29 January 2021

Hills of Gold Windfarm Project – SSD 9679 – Muswellbrook Shire Council Comment

I refer to the Environmental Impact Statement, prepared for Wind Energy Partners, and *Appendix G, Traffic and Transport Assessment* prepared by The Transport Planning Partnership, for the Hills of Gold Windfarm Project SSD - 9679. Council appreciates the opportunity for comment.

LEGEND
REFERENCE ONLY

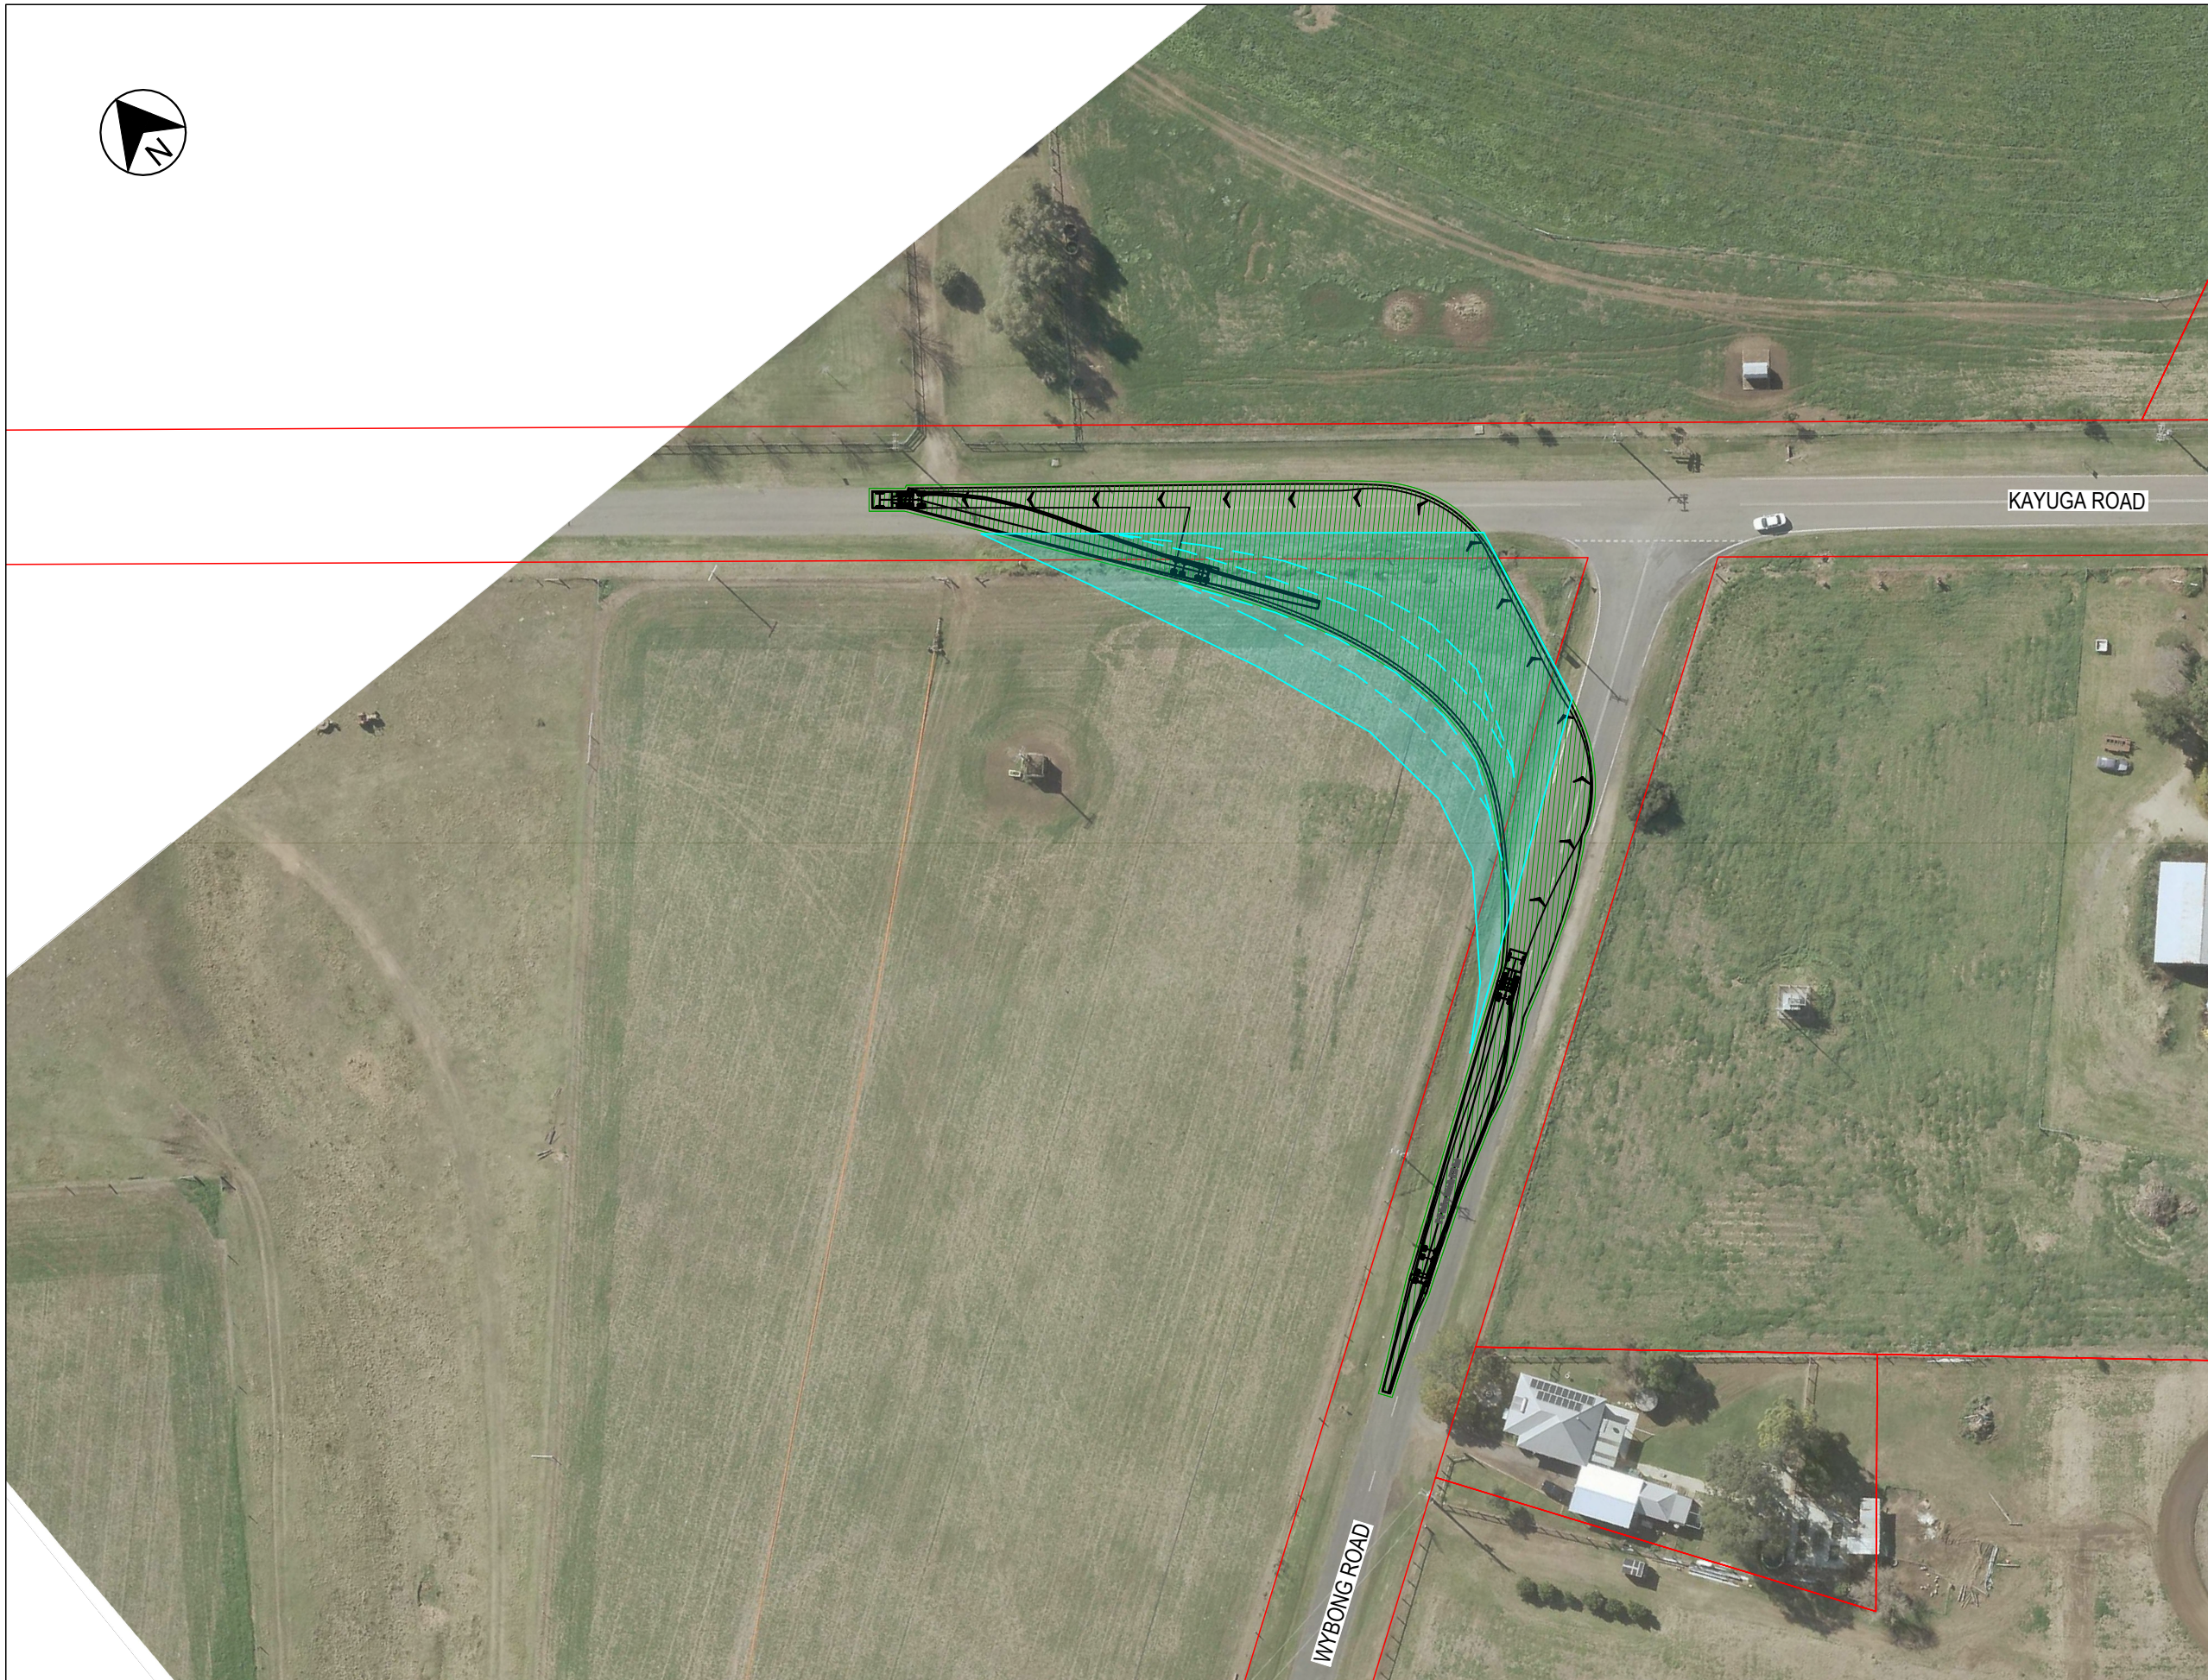
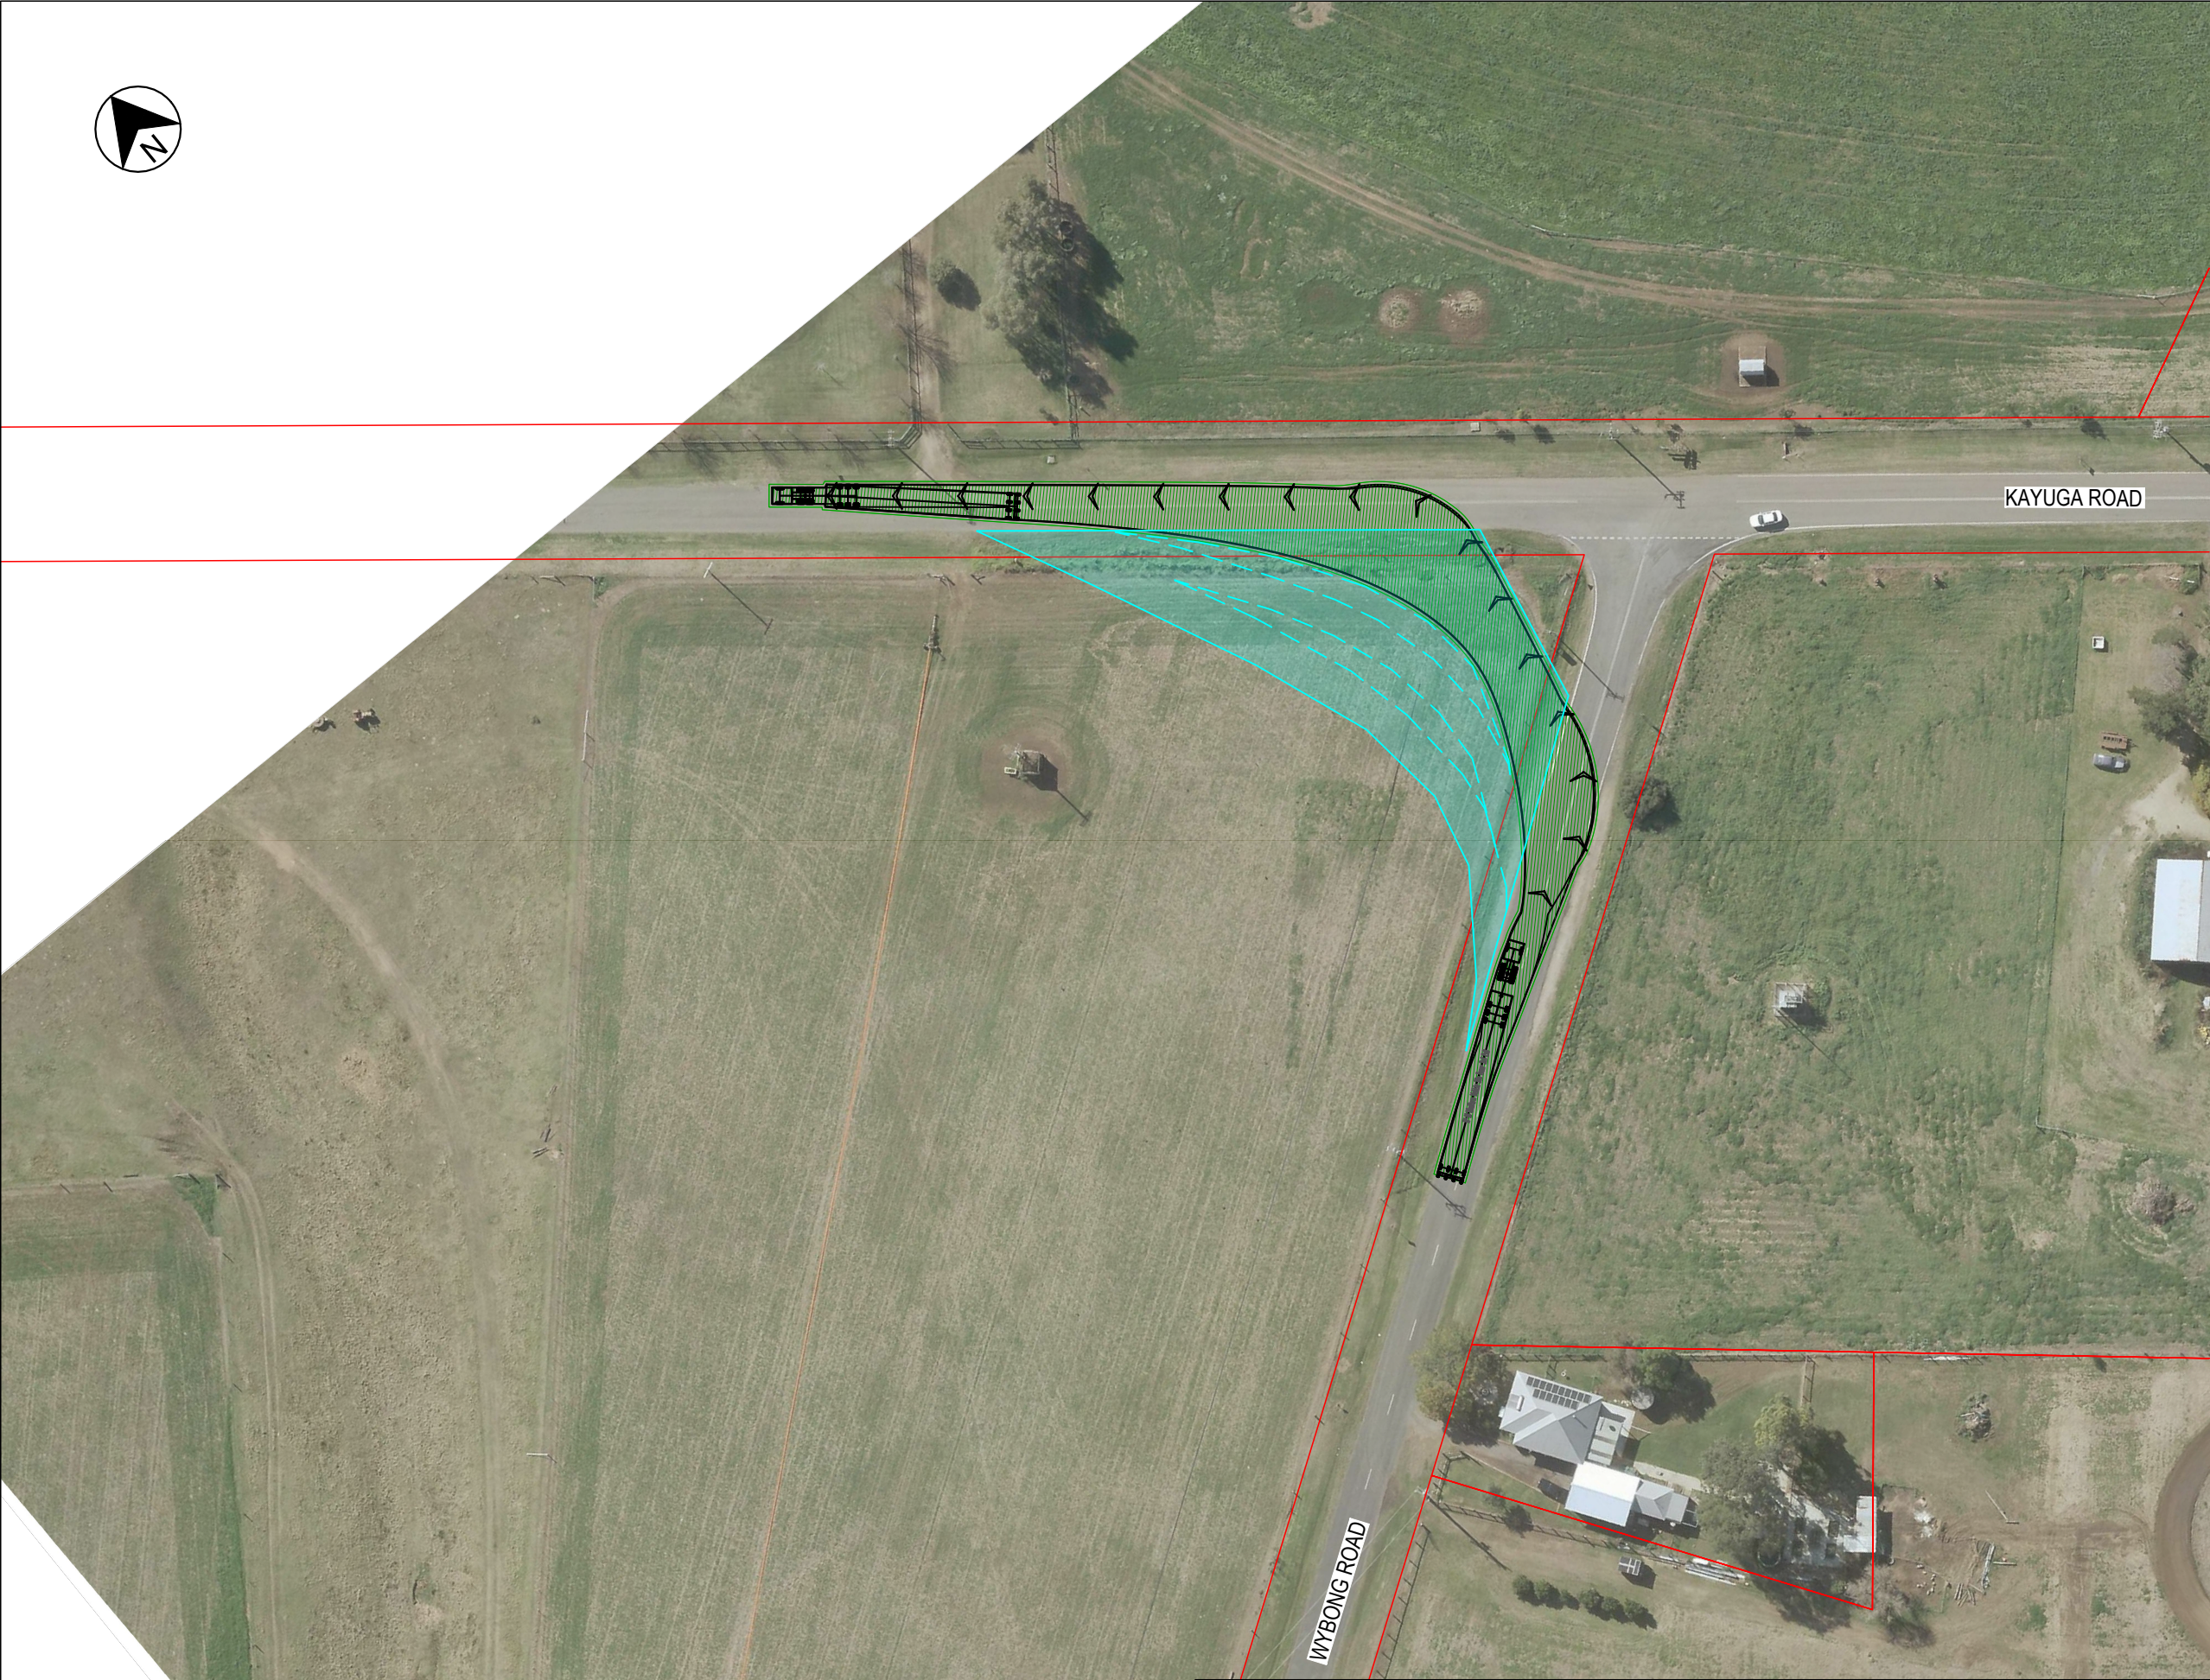
- Golden Highway;
- Thomas Mitchell Drive/Denman Road intersection;
- Thomas Mitchell Drive/New England Highway intersection;
- Bengalla Link Road;
- Bengalla Link Rd/Wybong Rd intersection;
- Wybong Road; and
- Kayuga Road.

6.0 The existing road alignment and constructed standard for sections of Wybong Road, Kayuga Road, Ivermein Street and Dartbrook Access Road are generally of a 'country road' standard with narrower lane widths, unformed shoulders, poor pavement, aged sealed surface, and drainage structures that will not support the proposed repeated heavy loads/turning movements. For example, the Rosebrook Bridge on Wybong Road has been assessed as inadequate structurally for supporting loads greater than local traffic (< 12 tonne mass limit). Several drainage structures and bridges along these roads also require upgrading to increase loading capacity.
